SF2014/0240830
CR2014/004402
KM

**DONALD STREET (MR82): NEW SPACE PROJECT, UNIVERSITY OF NEWCASTLE, 409
HUNTER STREET & 300 KING STREET, NEWCASTLE (SSD6457)**

Roads and Maritime has reviewed the Transport Access Study prepared by Seca Solutions, dated July 2014, and considers an appropriate assessment of road and traffic issues has not been undertaken. The critical assumptions which underpin the study, and the subjective information contained within the study, as outlined below, are currently not supported:

Figure 1-2 Mode Targets for NeW Space Students

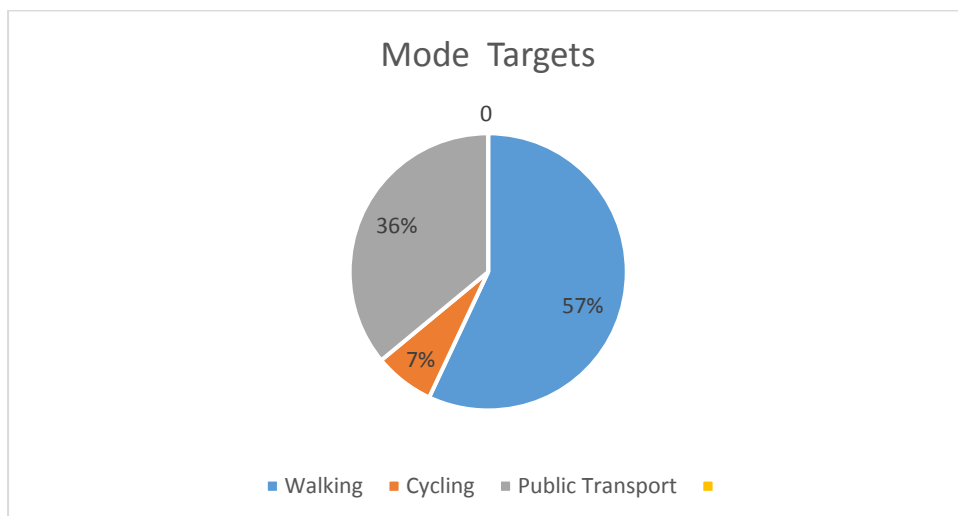
- A mode target rate of 0% cars for both future staff and students is not considered realistic or feasible. 91% of journeys to work in the Hunter are currently made by car (either as a driver or passenger), and *NSW 2021* has a target of increasing commuter trips by public transport to 20% by 2016. The Household Travel Survey 2010/2011 shows the Newcastle LGA as having the lowest rates of public transport usage and walking rates when compared to both Sydney and Illawarra.

Figure 4-5 Mode Targets for all NeW Space Students

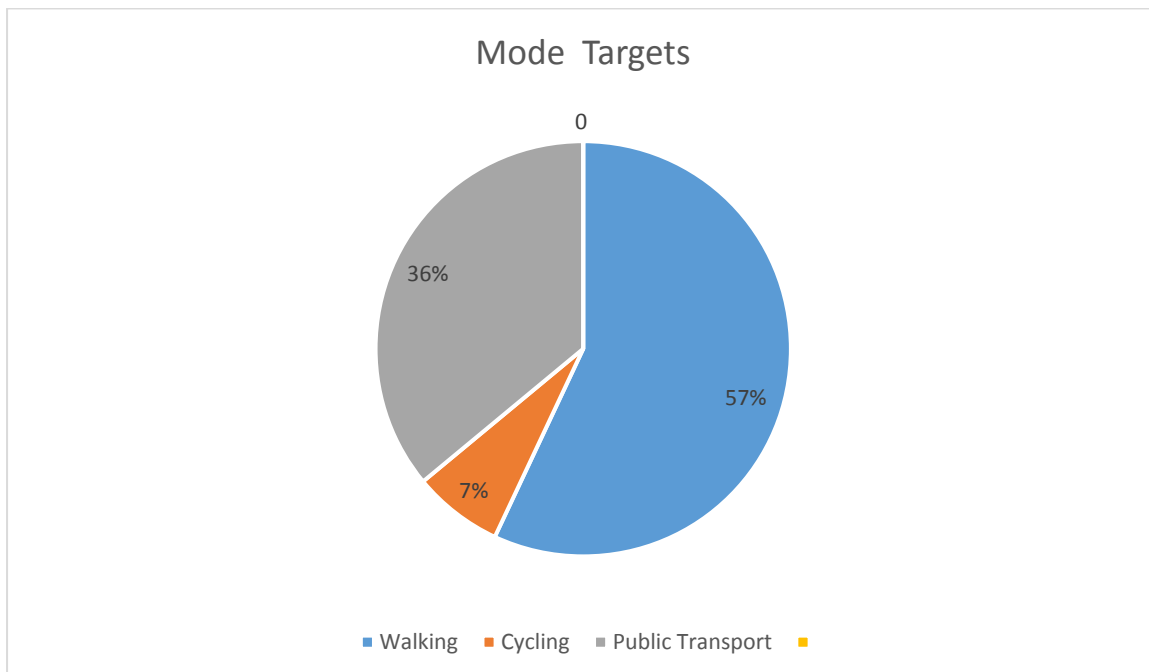
- The assumption of 36% of trips being made by public transport, when considering the above point, seems to be overly optimistic and without further justification and evidence is not supported.
